THURROCK FLEXIBLE GENERATION PLANT

Comments in relation to the supplementary documents submitted by the Applicant at Procedural Deadline C

PINS Reference Number	EN010092
Interested Party Reference Number	20025539
Document Ref.	PLA 3
Author	Winckworth Sherwood LLP
Date	25 January 2021

Land Plans
Sheet 4 of 4

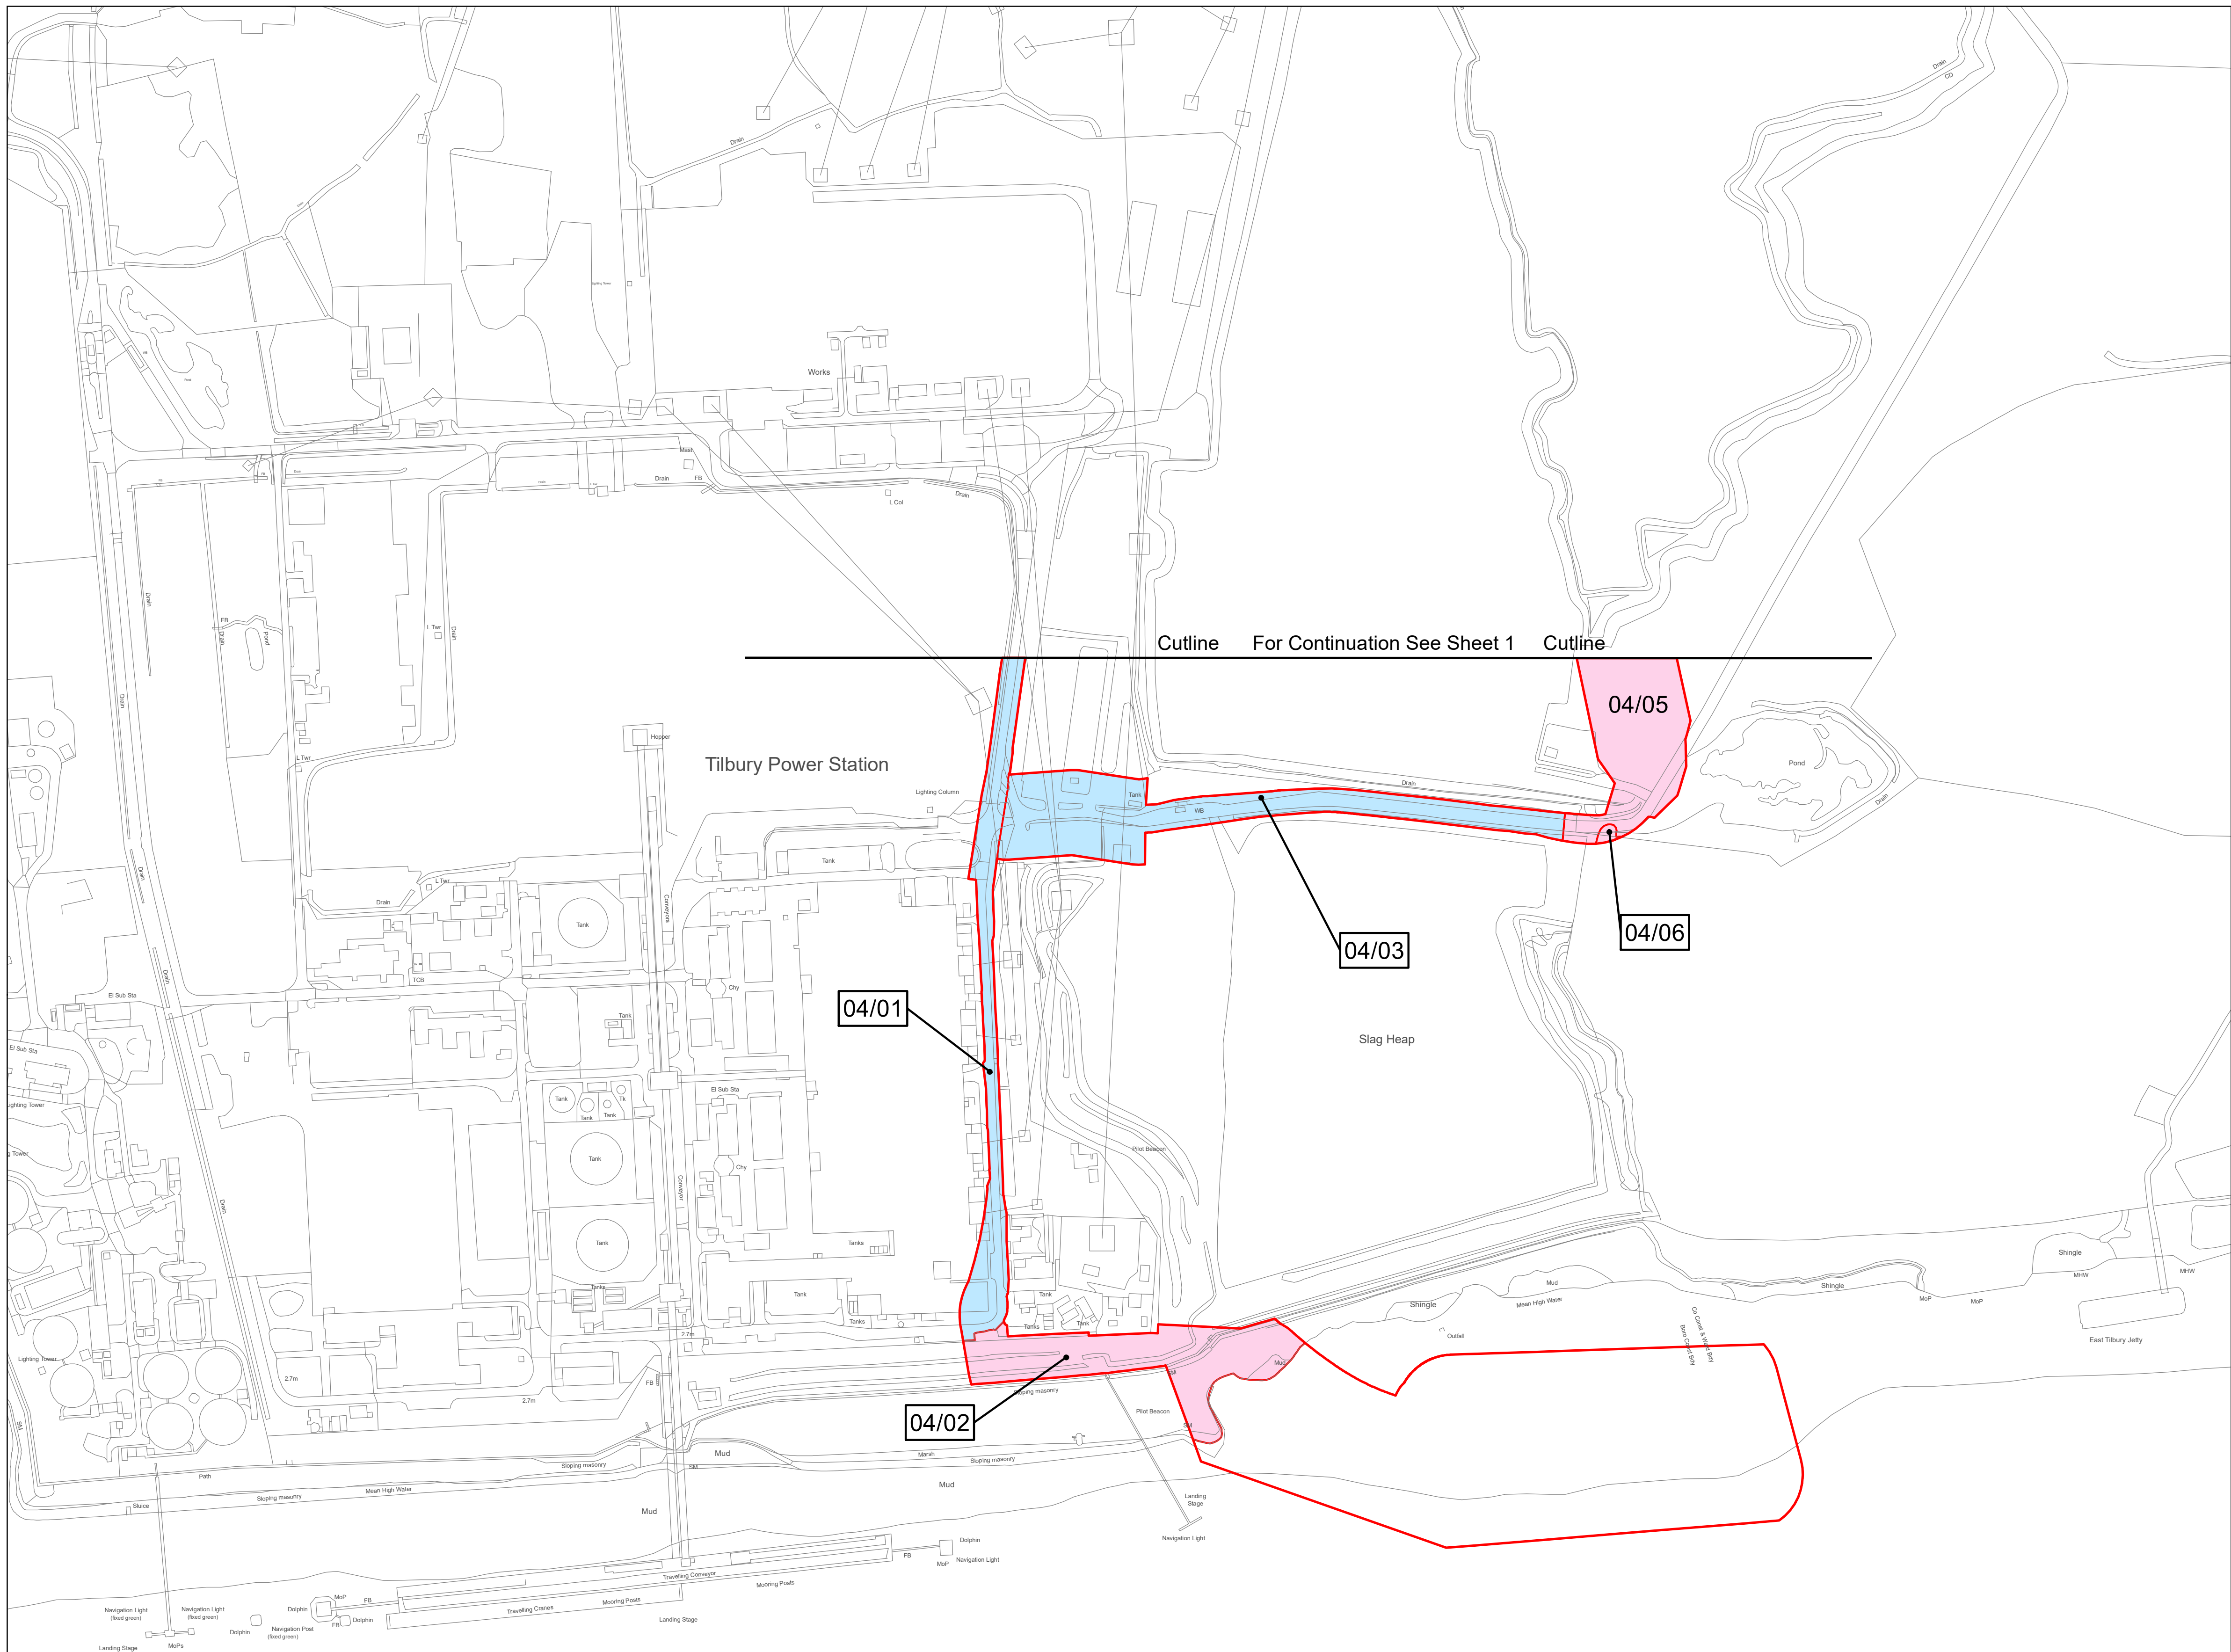
Reference	Extract	PLA comments
Land Plans – Sheet 4 of 4		See comments on limits of deviation in relation to PDC-056.

Reference	Extract	PLA comments
Sheet 6 of 6	Work no. 10 limit of deviation	This plan shows that the limit of deviation for Work no.10 has not decreased despite the removal of Work no.9 (which shared that limit) from the authorised development. The PLA considers this limit to be excessive given the size and shape of the causeway and berth pocket shown in the Concept Design document for the causeway and the fact that the proposed construction method is understood to be working within the footprint of the causeway and from the shore outwards. The PLA therefore requests that a revised plan be submitted to show a more appropriate limit of deviation for Work no.10. If necessary, and as suggested in relation to new article 37 (Power to dredge), a separate dredging limit/plan should be adopted for the Work.

Thurrock Flexible Generation Plant
Location and Order Limits Plans
Sheet 5 of 5

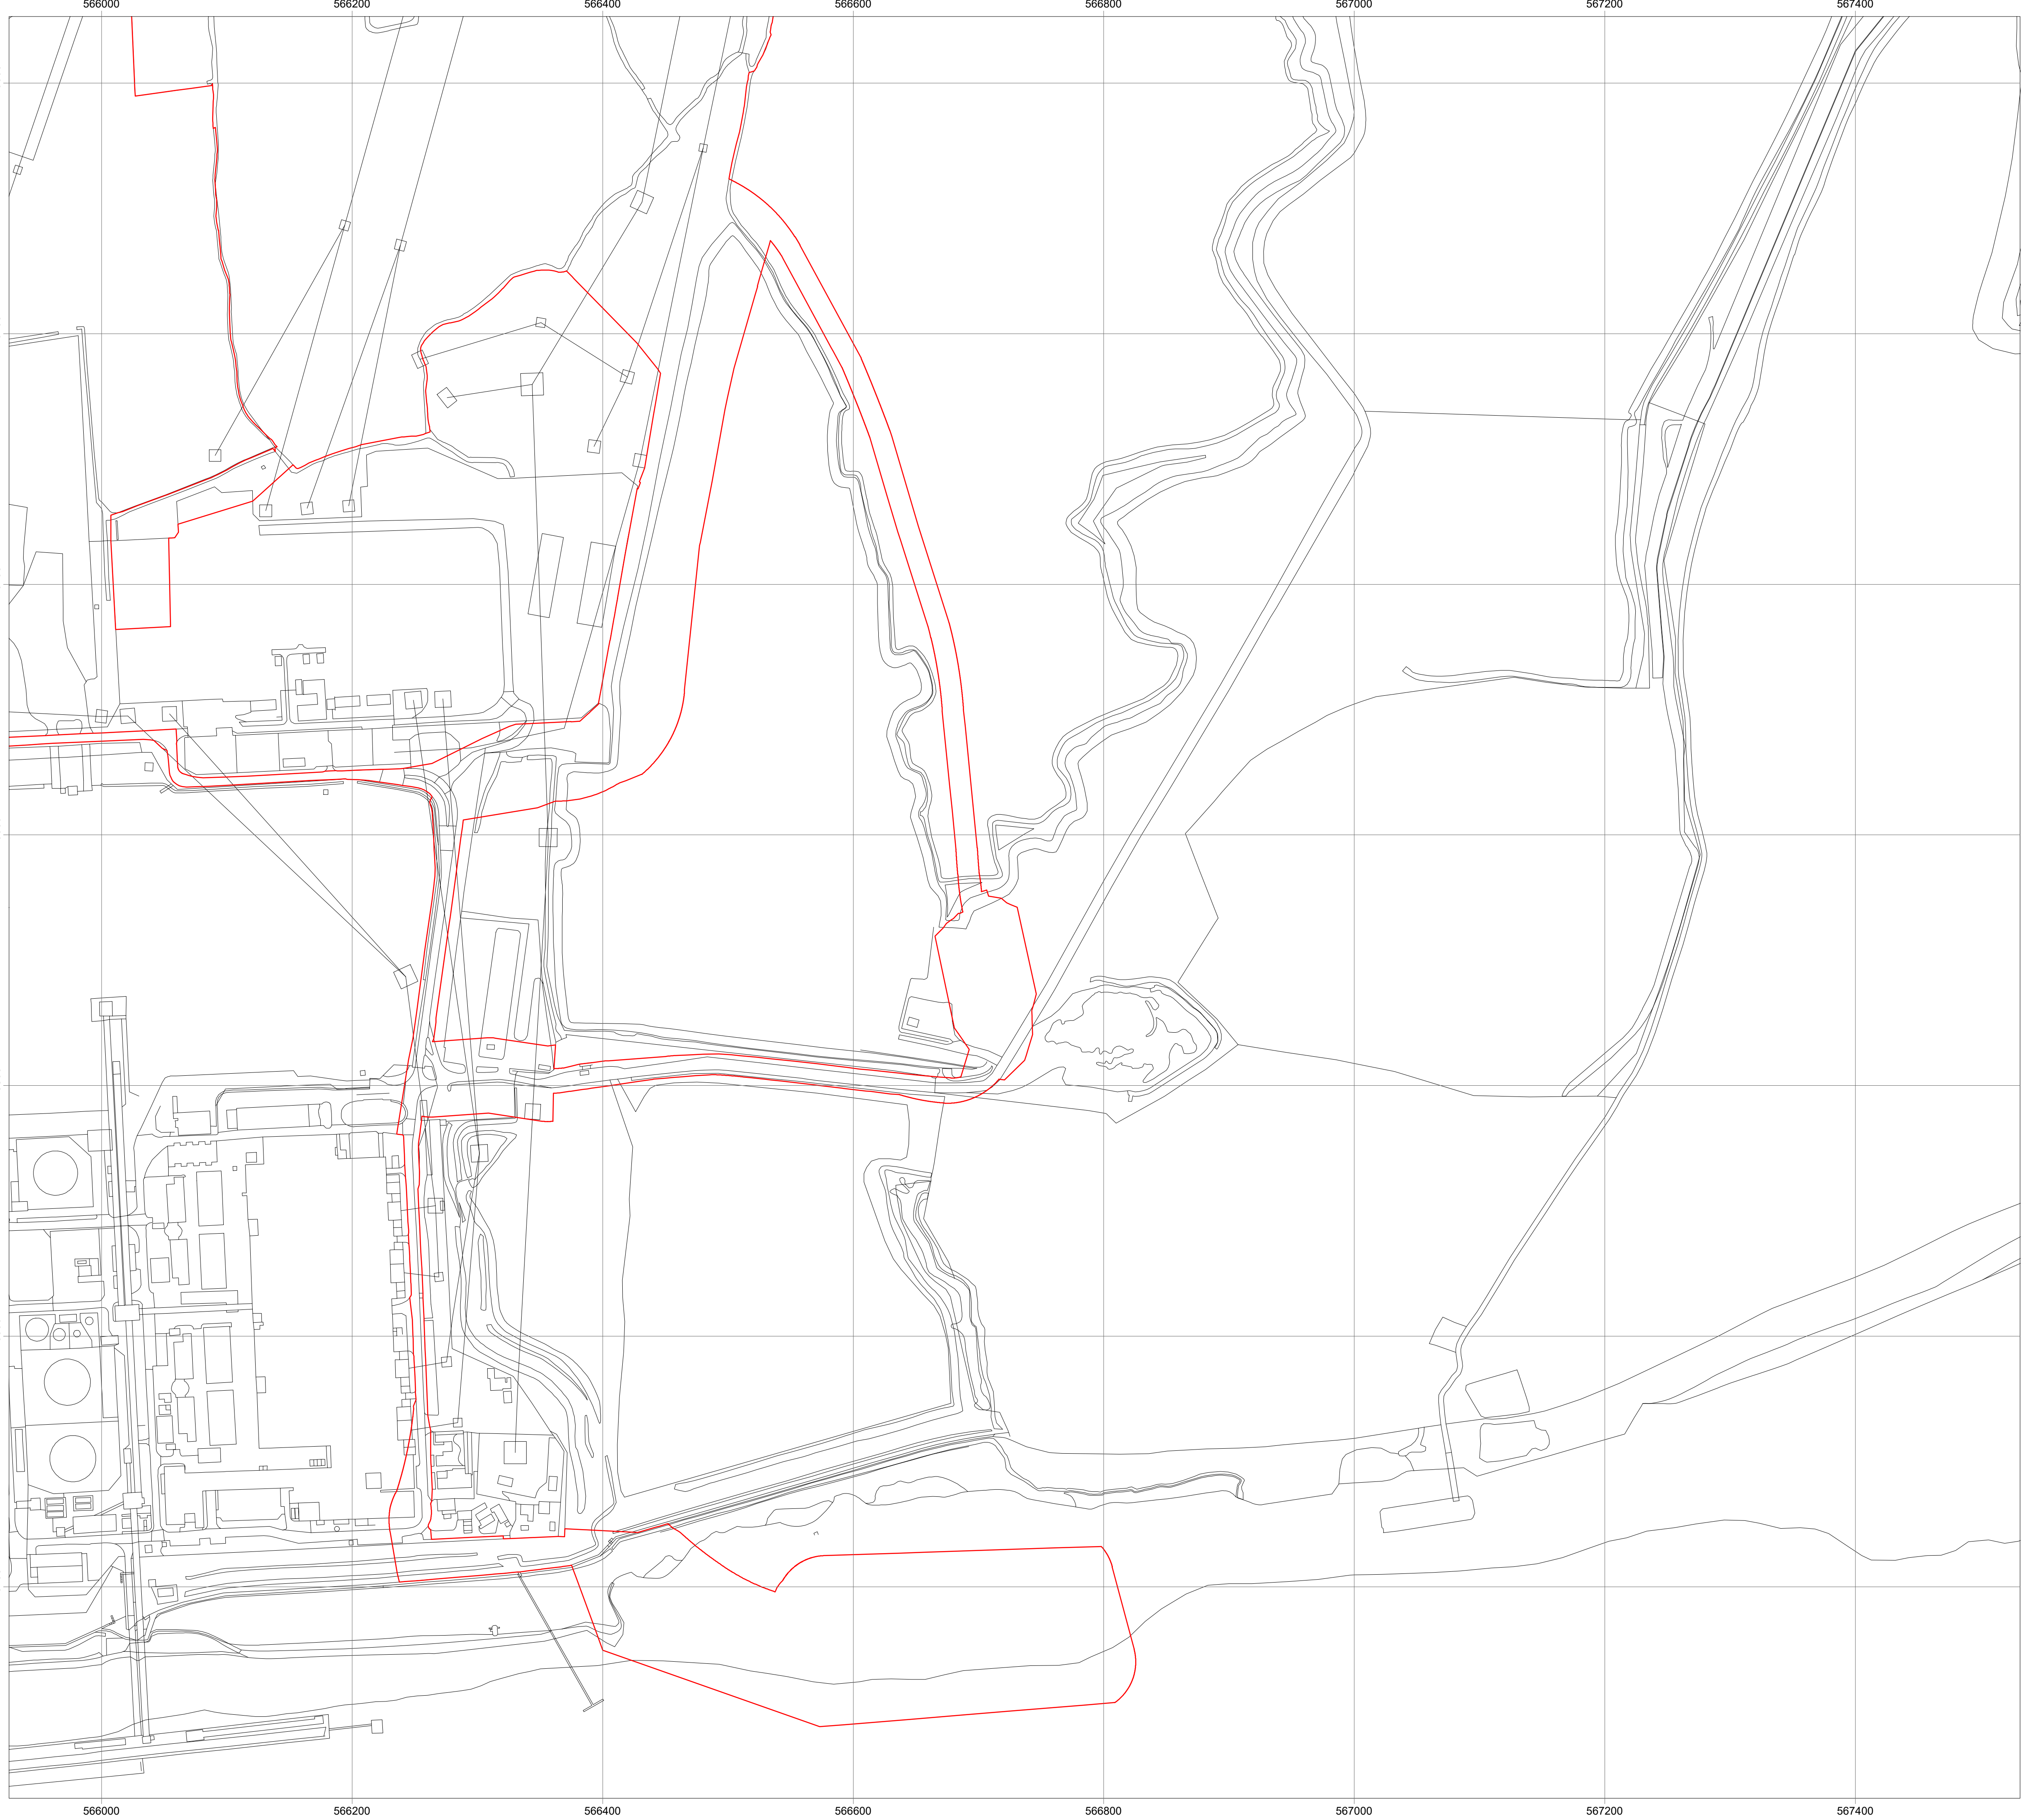
Reference	Extract	PLA comments
Location & Order Land Plans – Sheet 5 of 5		See comments on limits of deviation in relation to PDC-056.
